**ANGEL PLACE
LEVEL 8, 123 PITT STREET
SYDNEY NSW 2000**

2 September 2022

RESPONSE TO REQUEST FOR INFORMATION - INTERCONTINENTAL HOTEL ALTERATIONS AND ADDITIONS MODIFICATION 2 (SSD 7693 MOD 2)

SETBACK DIAGRAM

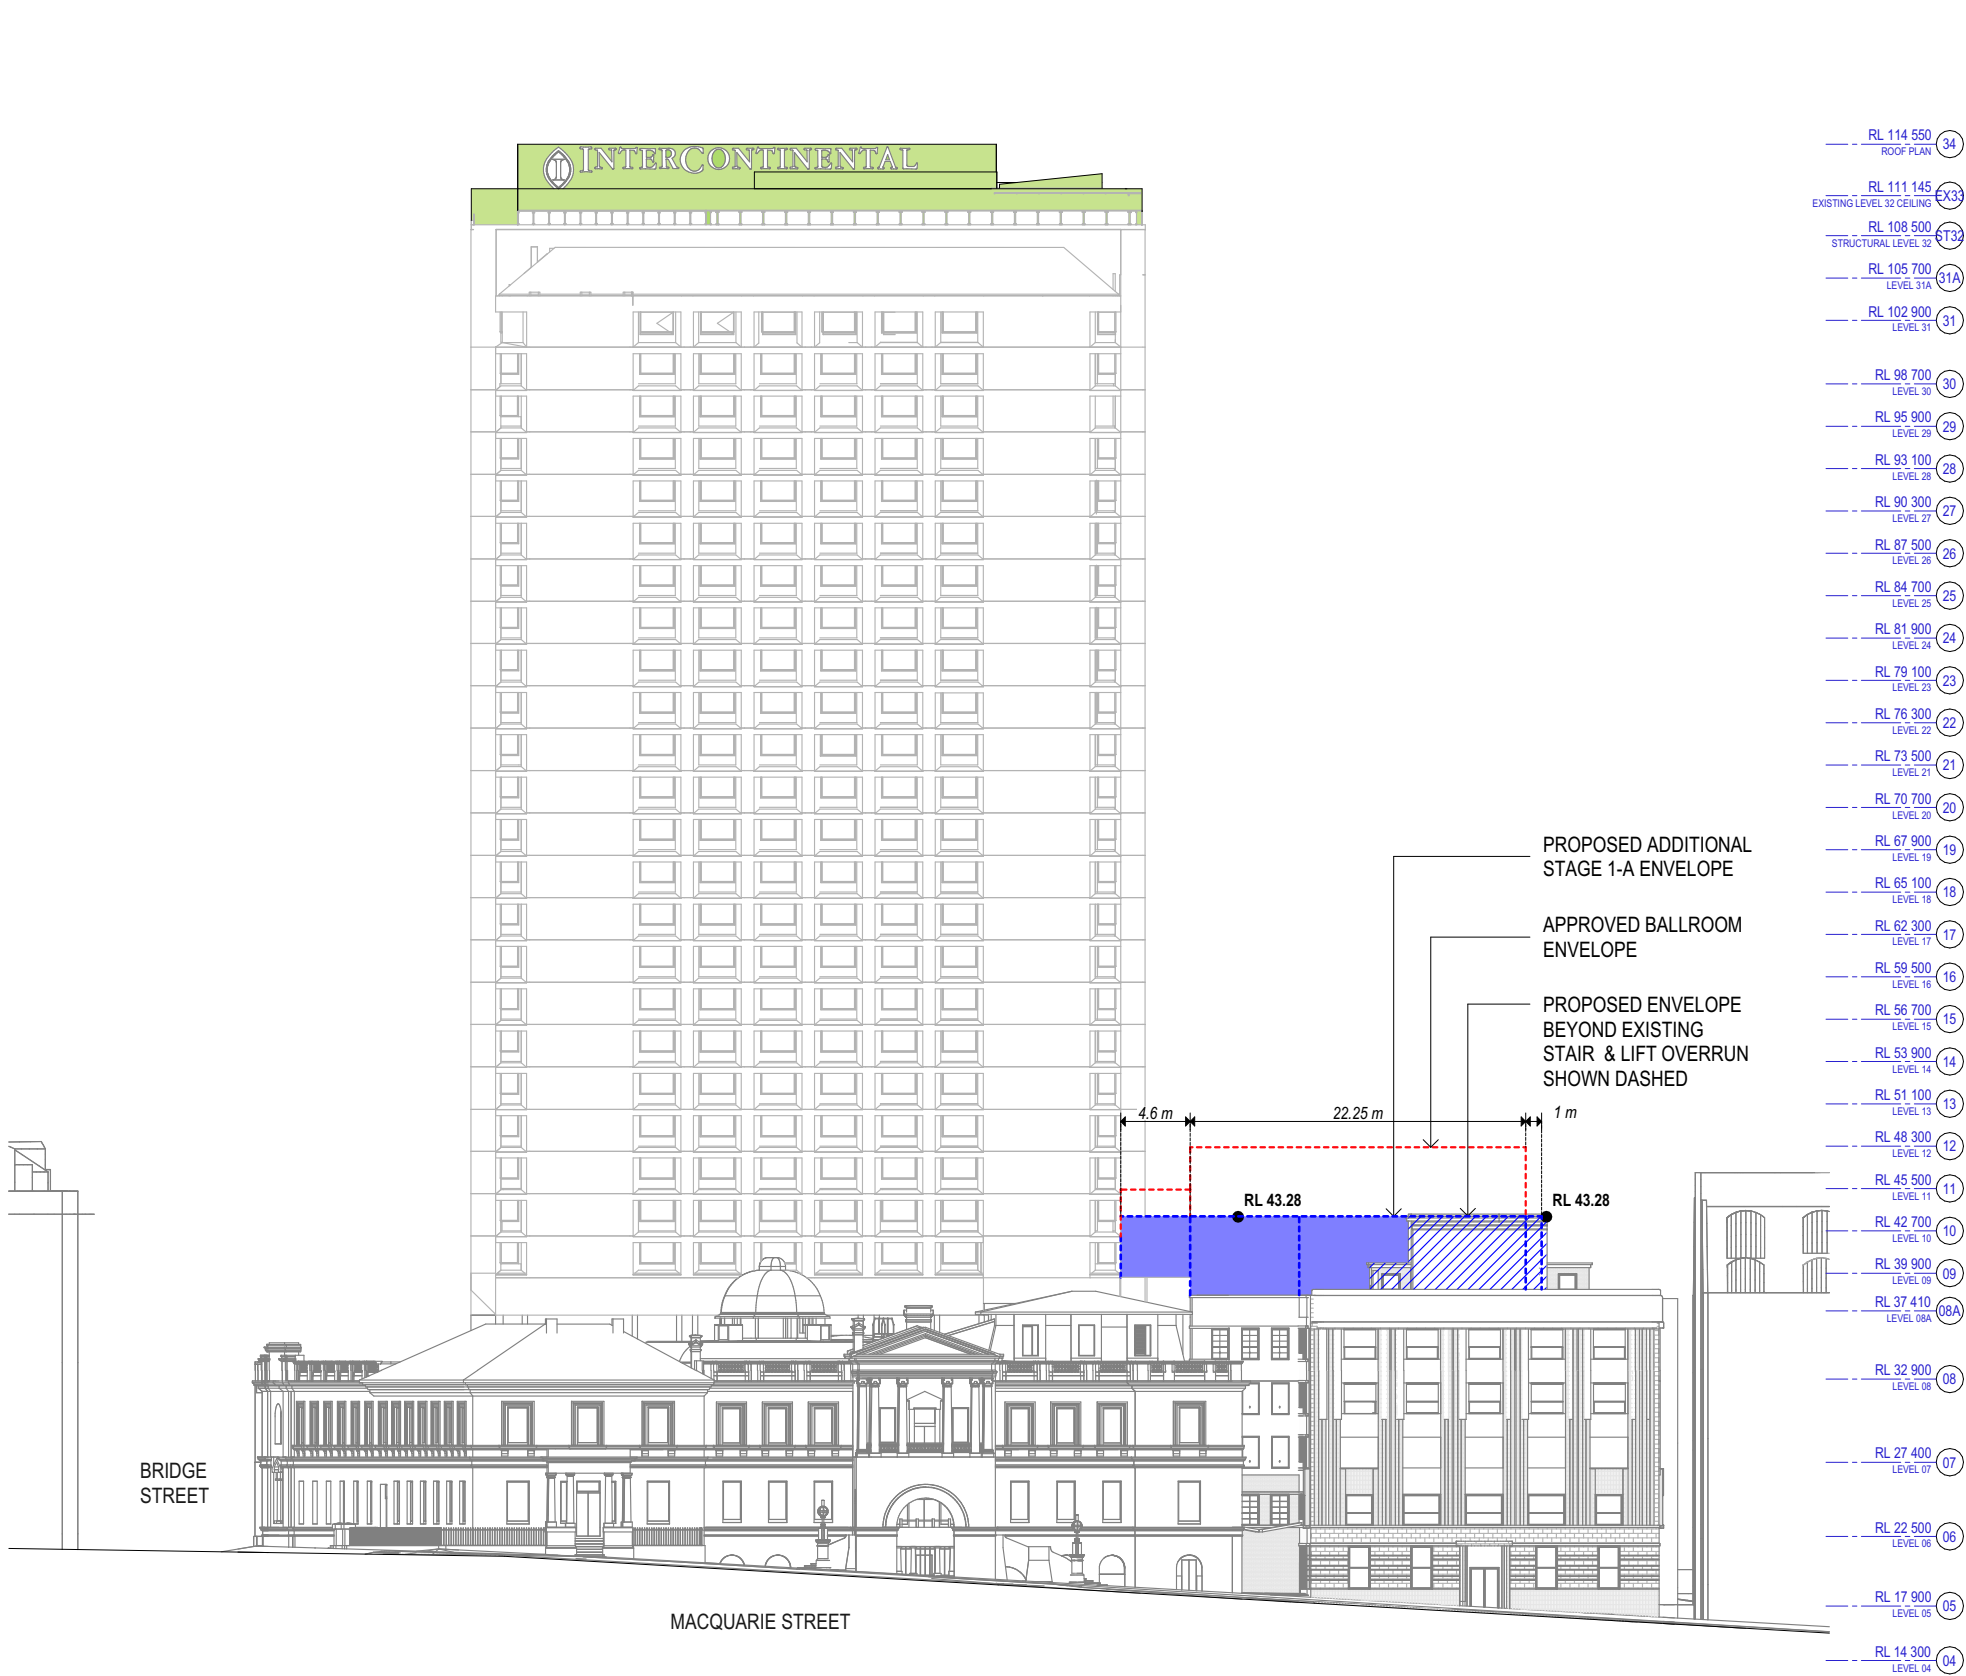
It is noted that the existing (envelope) approval provides an 8.5m setback to Phillip Street. This setback is generally aligned with the existing built structures on the roof.

The amended envelope seeks a very minor non-compliance with the approved setback to enable space for the proposed lift/link connection to/from the Intercontinental Hotel. Mulpha found the new lift/link location provides a more logical connection point to/from the Intercontinental Hotel.

TRANSPORT HOUSE
99 MACQUARIE ST, SYDNEY
MULPHA
TITLE
SECTIONS
JOB No 6680
DWG No 3101
ISSUE D

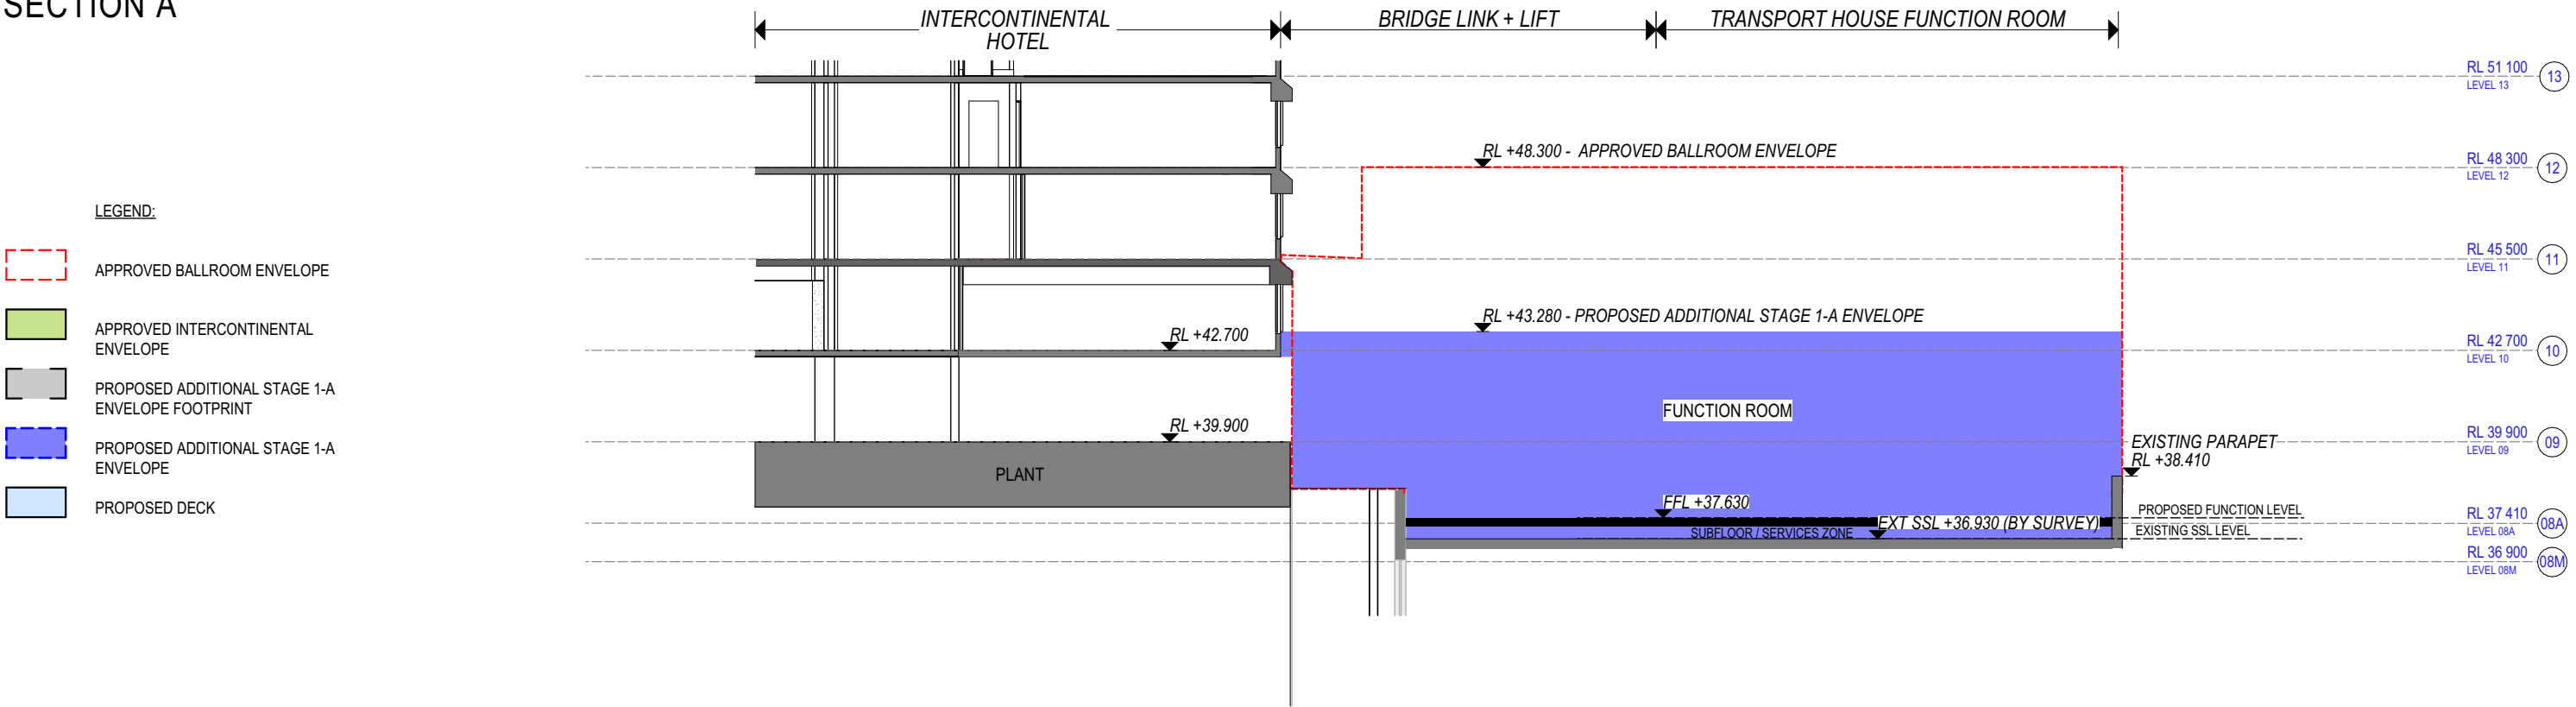
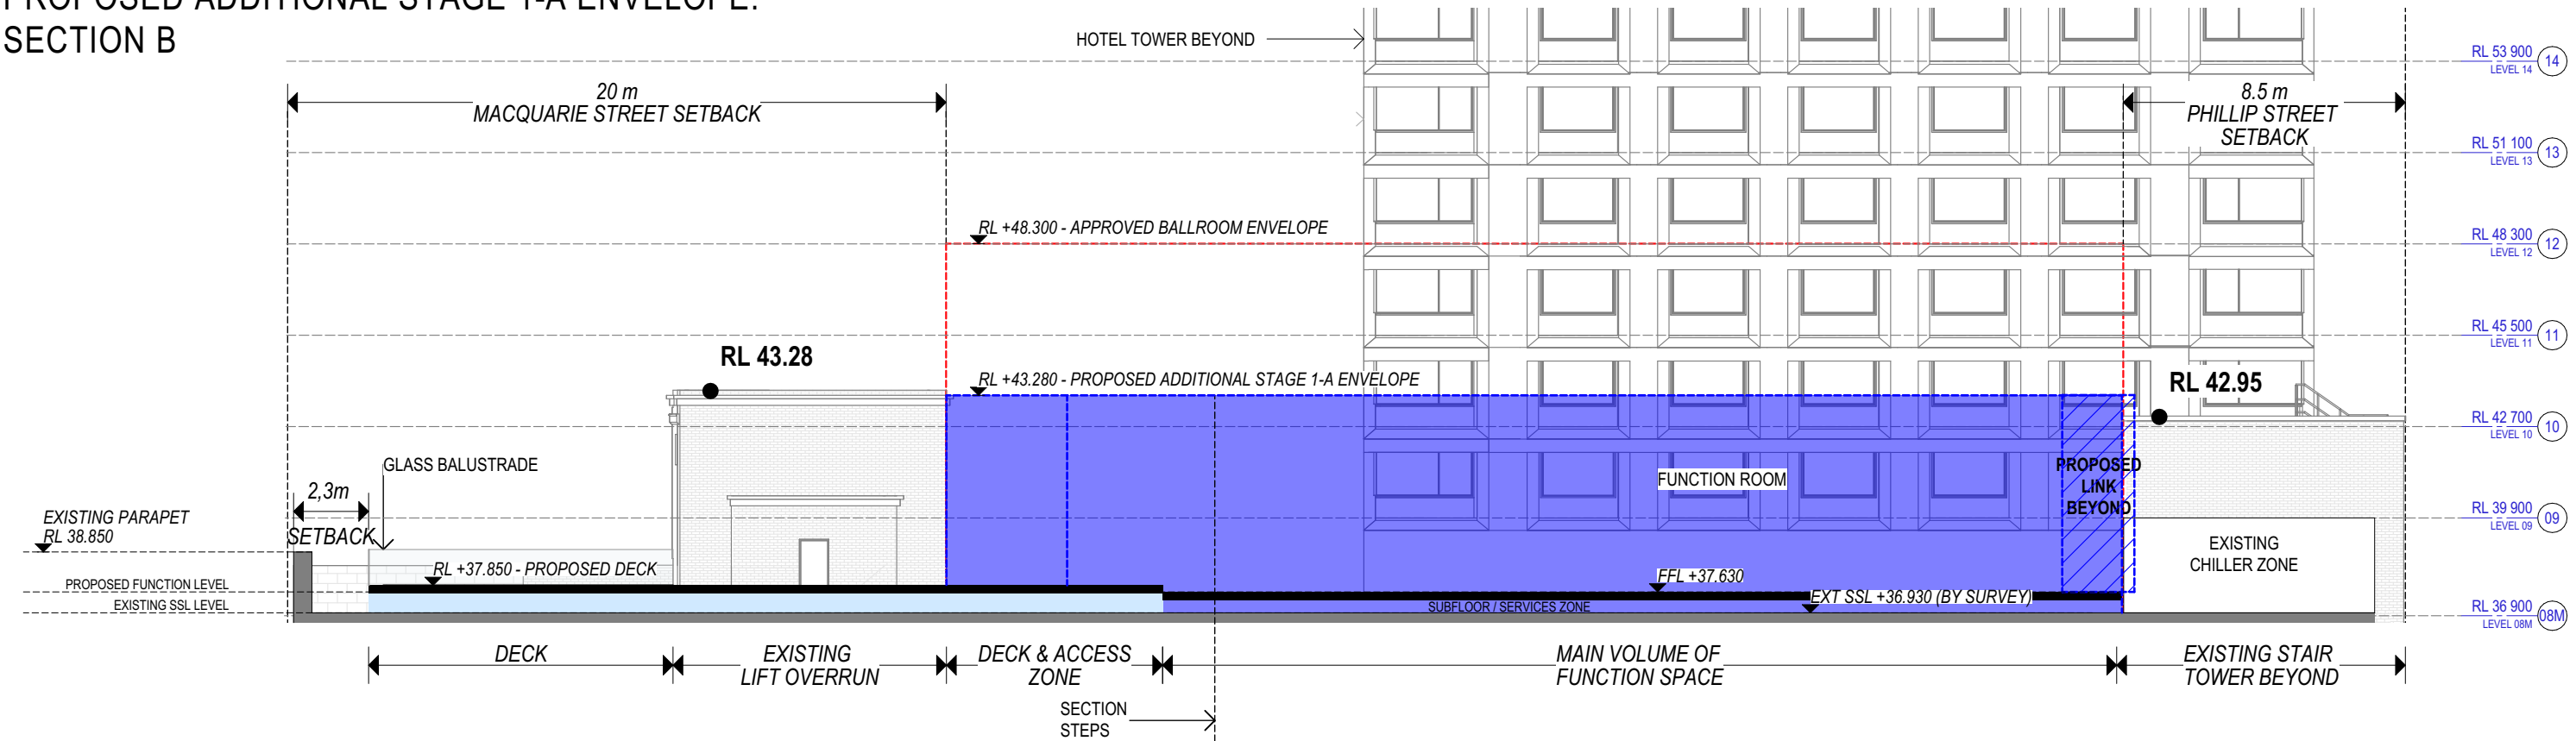
Issue	Response
<p>There is no valid justification for the proposed roof deck to be 900mm higher than existing level and 220mm higher than proposed function room level. The effective existing parapet height is only 1m meaning occupants and any tall element will be visible in views. It is recommended that the floor level is lowered to match or preferably be lower than the proposed function room level.</p>	<p>The proposed deck structure is proposed to be raised 900mm higher than the existing level to accommodate services and to enable guests an opportunity to observe the expansive views afforded by the site. Access to views is critical to the commercial viability and attractiveness of the function centre offering.</p> <p>As above, the visual impacts of this move are considered to be supportable on heritage and visual impact grounds.</p>
<p>Clarification regarding staging and the proposed addition being a temporary structure to be removed is noted. It is recommended that a condition of consent is included to this effect.</p>	<p>The temporary function centre will be wholly removed from the site before the Ballroom is constructed, subject to the need to retain any points of access (including the bridge link) for the future ballroom.</p> <p>A condition of consent to this effect is supported.</p>

PROJECT NAME		
STREET, CITY		
CLIENT - CLIENT		
TITLE		
VIEW 01-ALFRED STREET VIEW		
JOB No	DWG No	ISSUE
6680	SD2823	05

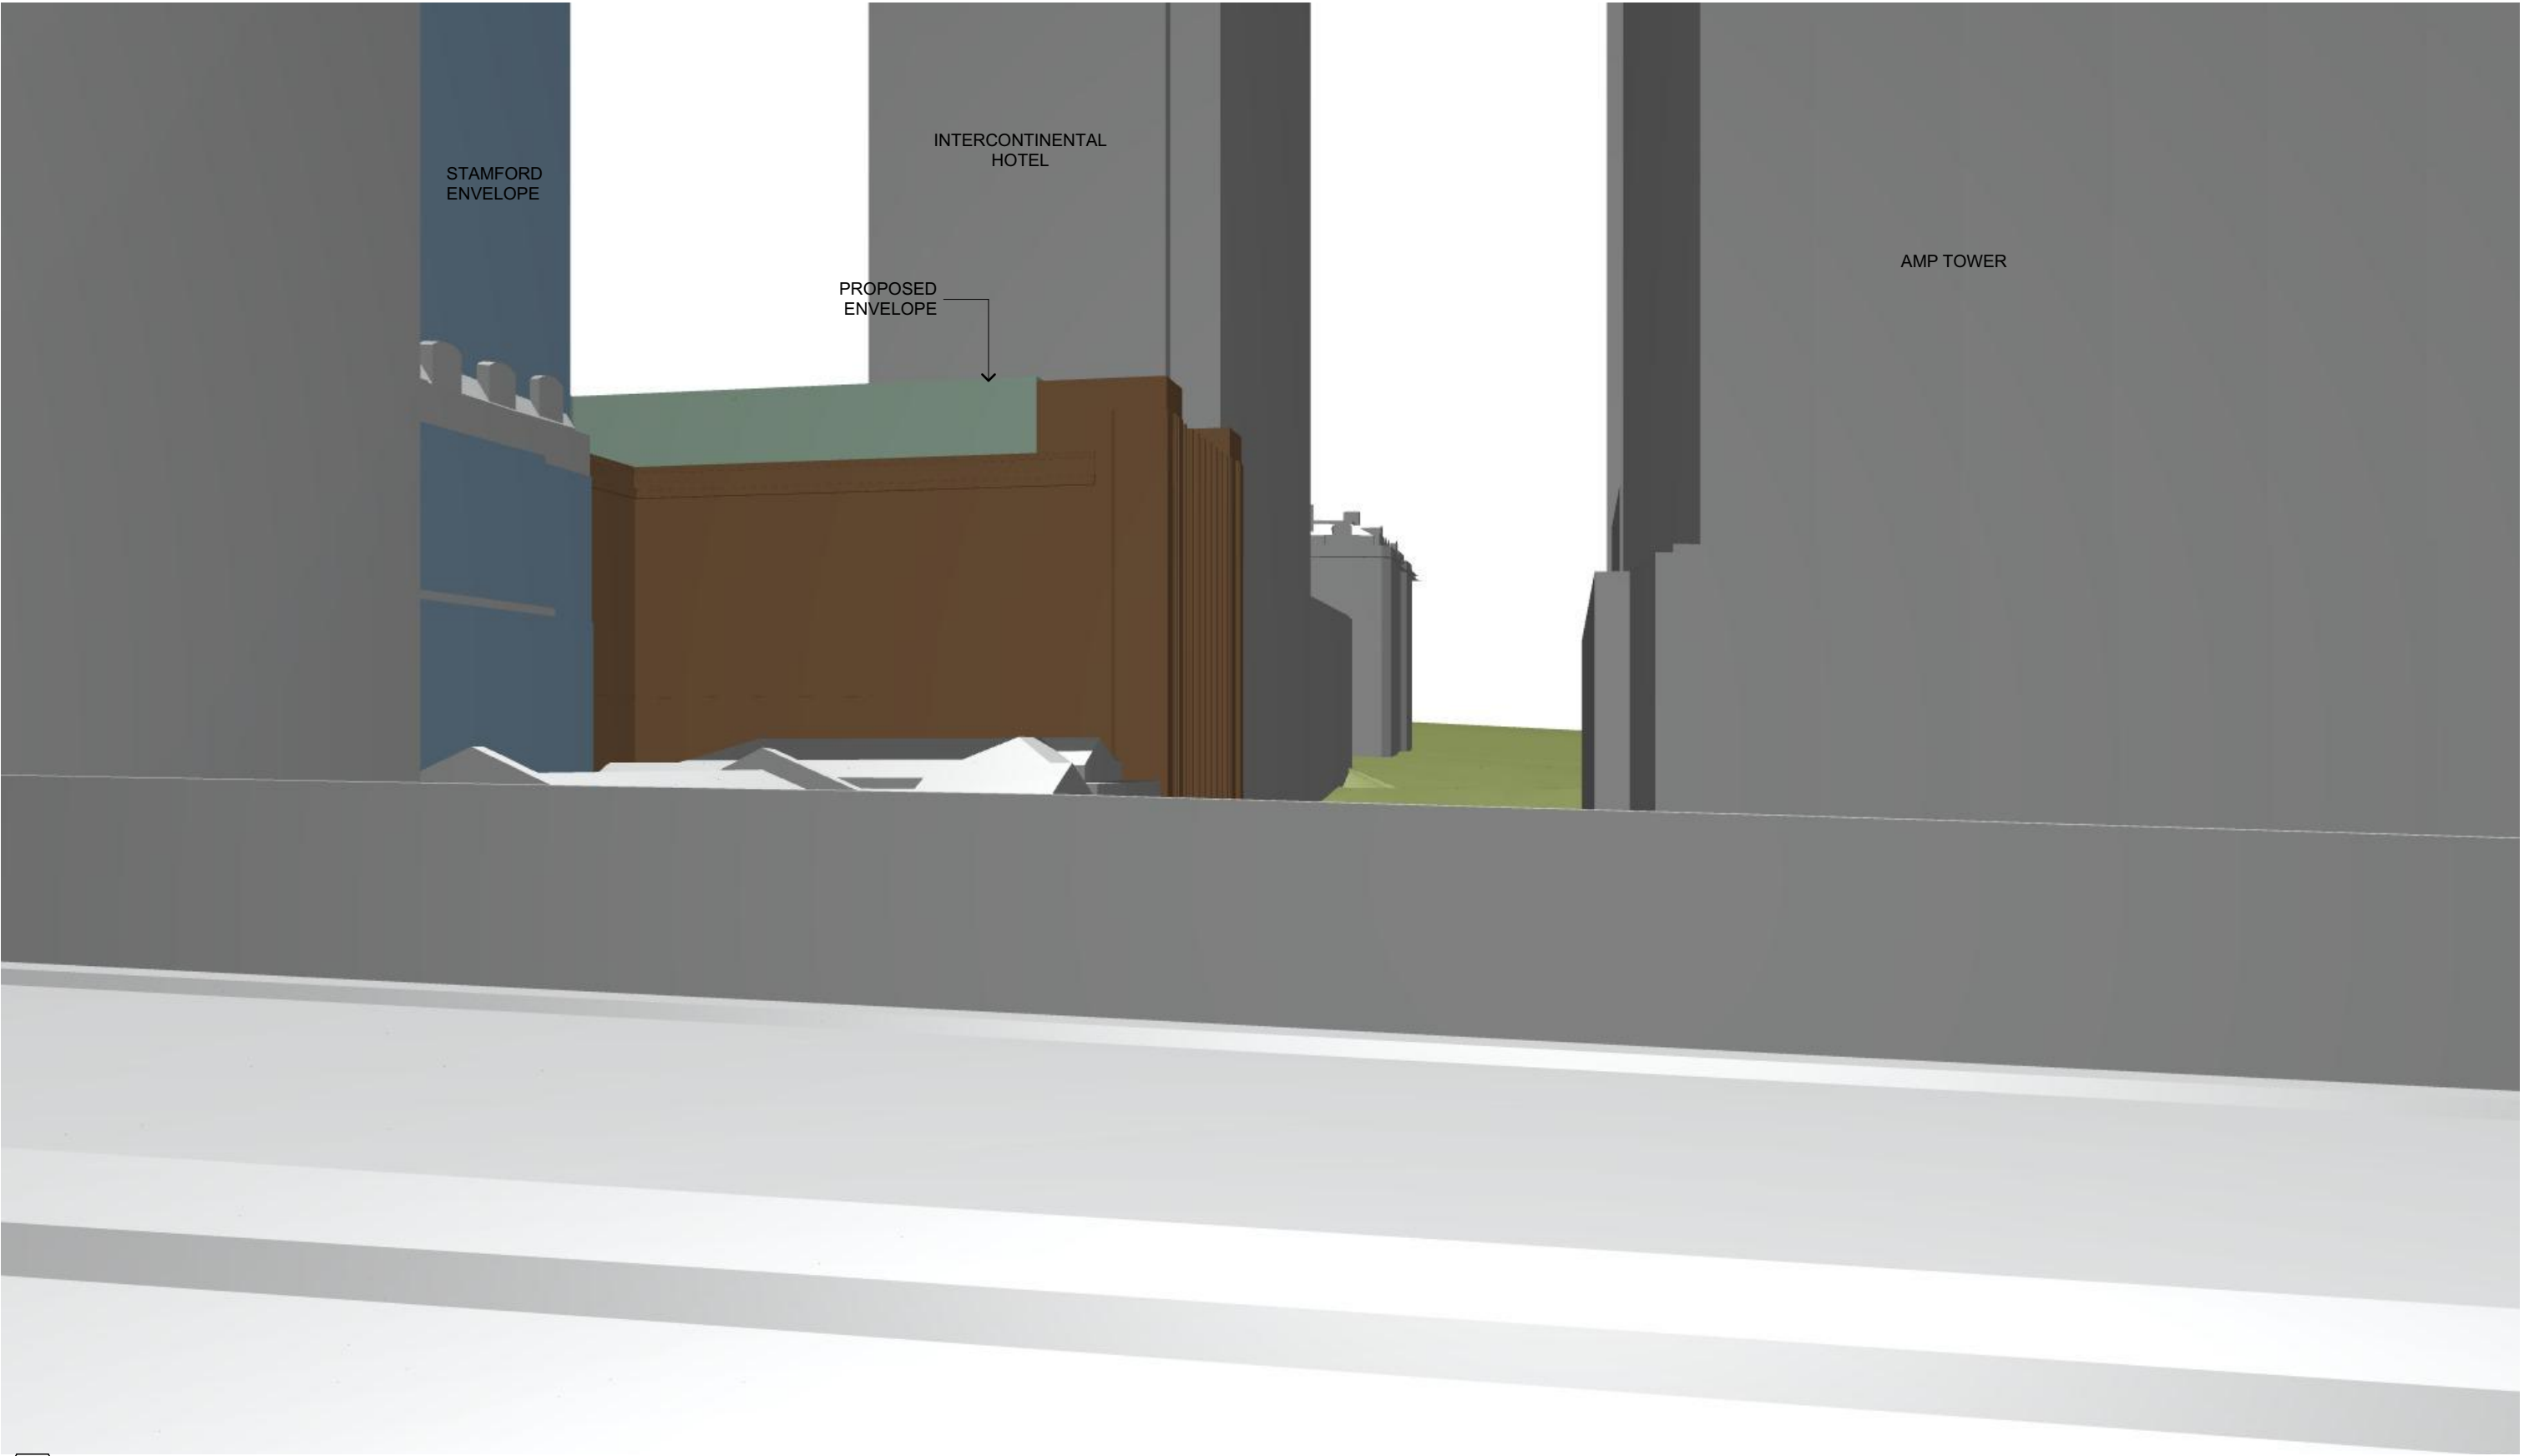
Cottee Parker have prepared a view study of the proposed Phillip Street elevation from key vantage points (Appendix A). The view study demonstrates that from key vantage points, the proposed lift connection is shielded by the existing plant deck area. Refer to the figures below.

The minor lift connection will not be visible from key vantage points and will not create any negative heritage or visual impacts. Therefore, the initial reasons for approval remain valid and this minor modification will not have any consequential environmental impacts.
